Rezoning Transportation Analysis

Petition Number: 2023-035

Date	Description
7-26-23	First Review (PM)

RZ-1
Sheet 1 of 2

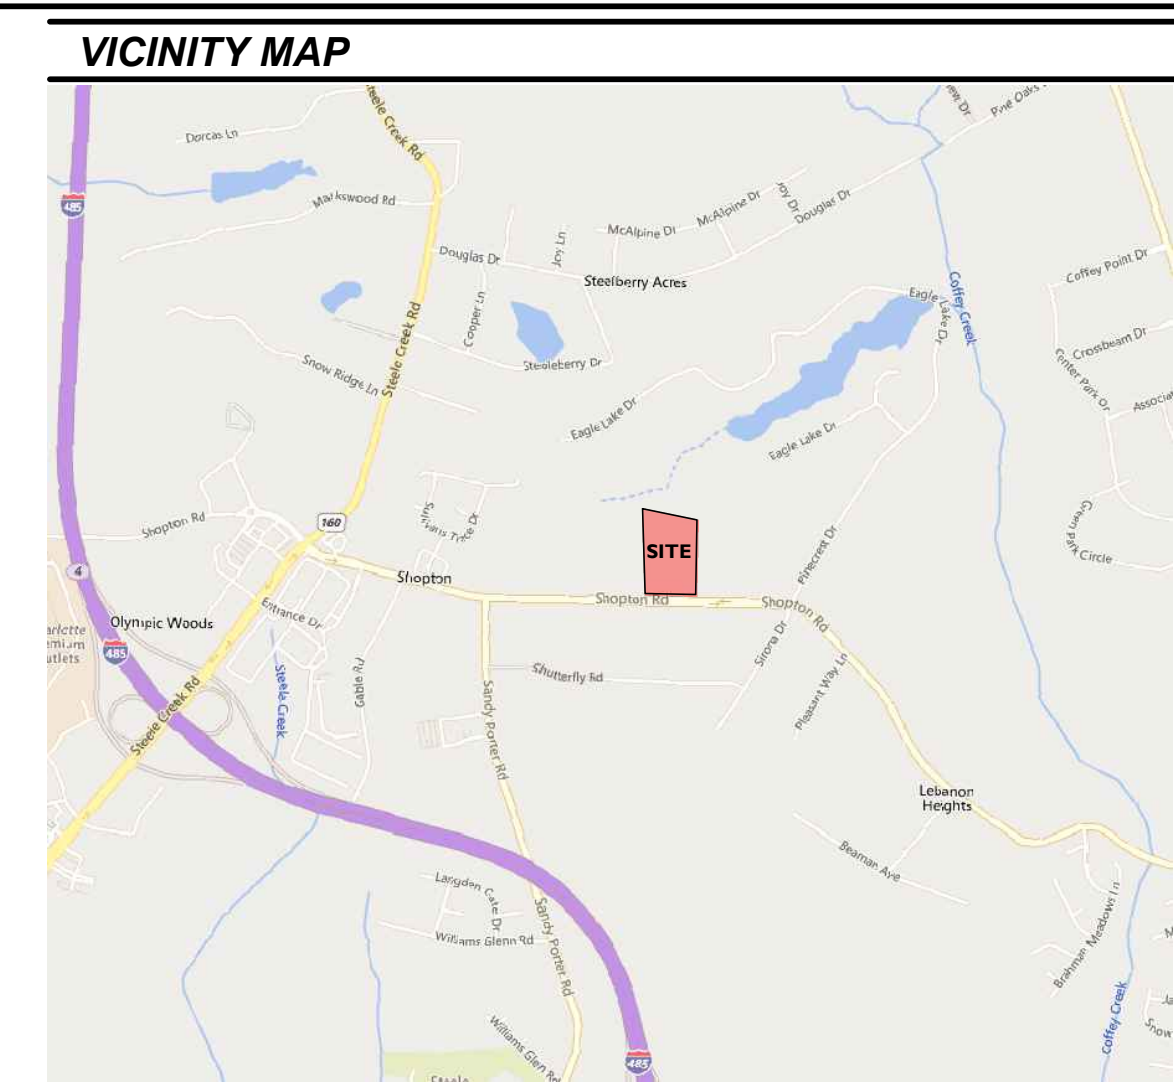
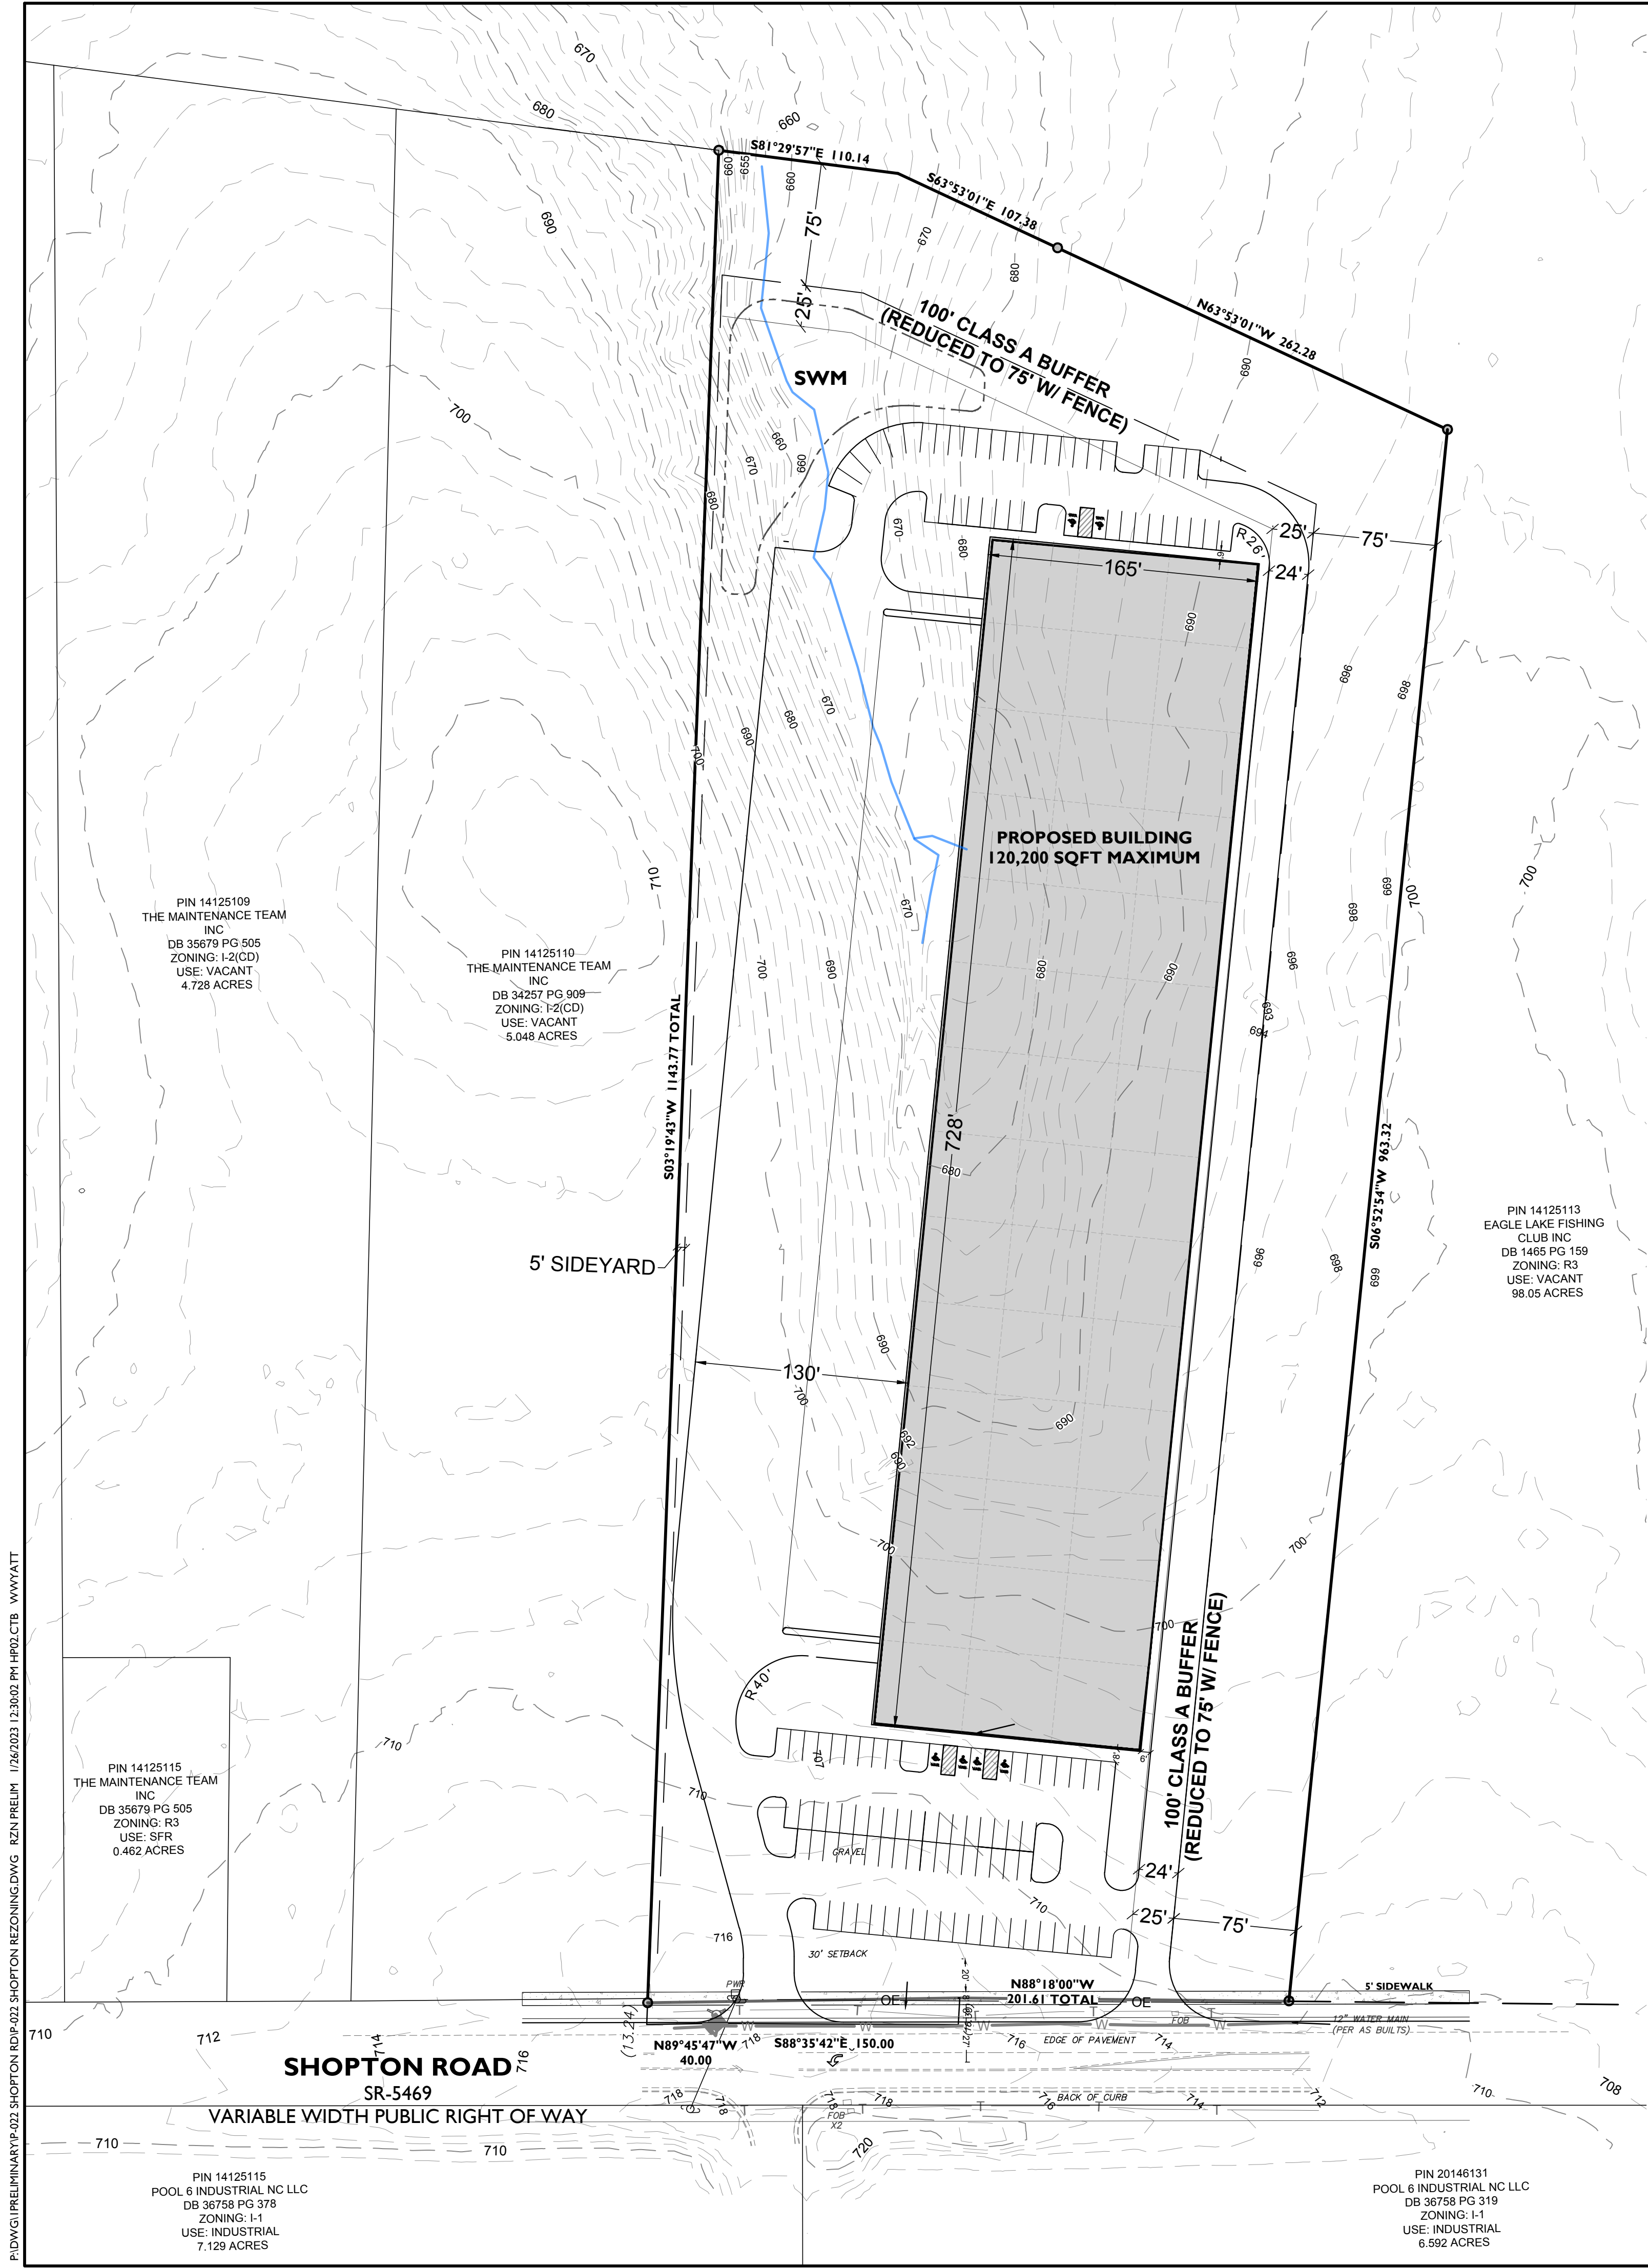
- a. **Shopton Road:** Location of curb and gutter to be moved to 27 feet from roadway centerline to accommodate the Charlotte Streets Map with a roadway typical section of a two plus lane avenue with buffered bike lanes.

Label and dimension the curb and gutter from the centerline for each road on the site plan.

3. The site plan shall label and dimension the right-of-way from the road centerline.
4. Revise site plan and conditional note(s) to commit to construct an 8-foot planting strip, and 8-foot sidewalk on Shopton Road per Chapter 19. The site plan shall label and dimension both items from the back of curb and gutter or edge of pavement.

5. Revise site plan and conditional note(s) to commit to construct bicycle facilities by locating the curb and gutter 27' from the center line to meet the Council-adopted Charlotte BIKES Policy.

7. Per coordination with NCDOT, revise site plan and conditional note(s) to commit to installing a left turn lane into the site from Shopton Road.
8. Per coordination with NCDOT, revise the site plan to remove the sites eastern access.
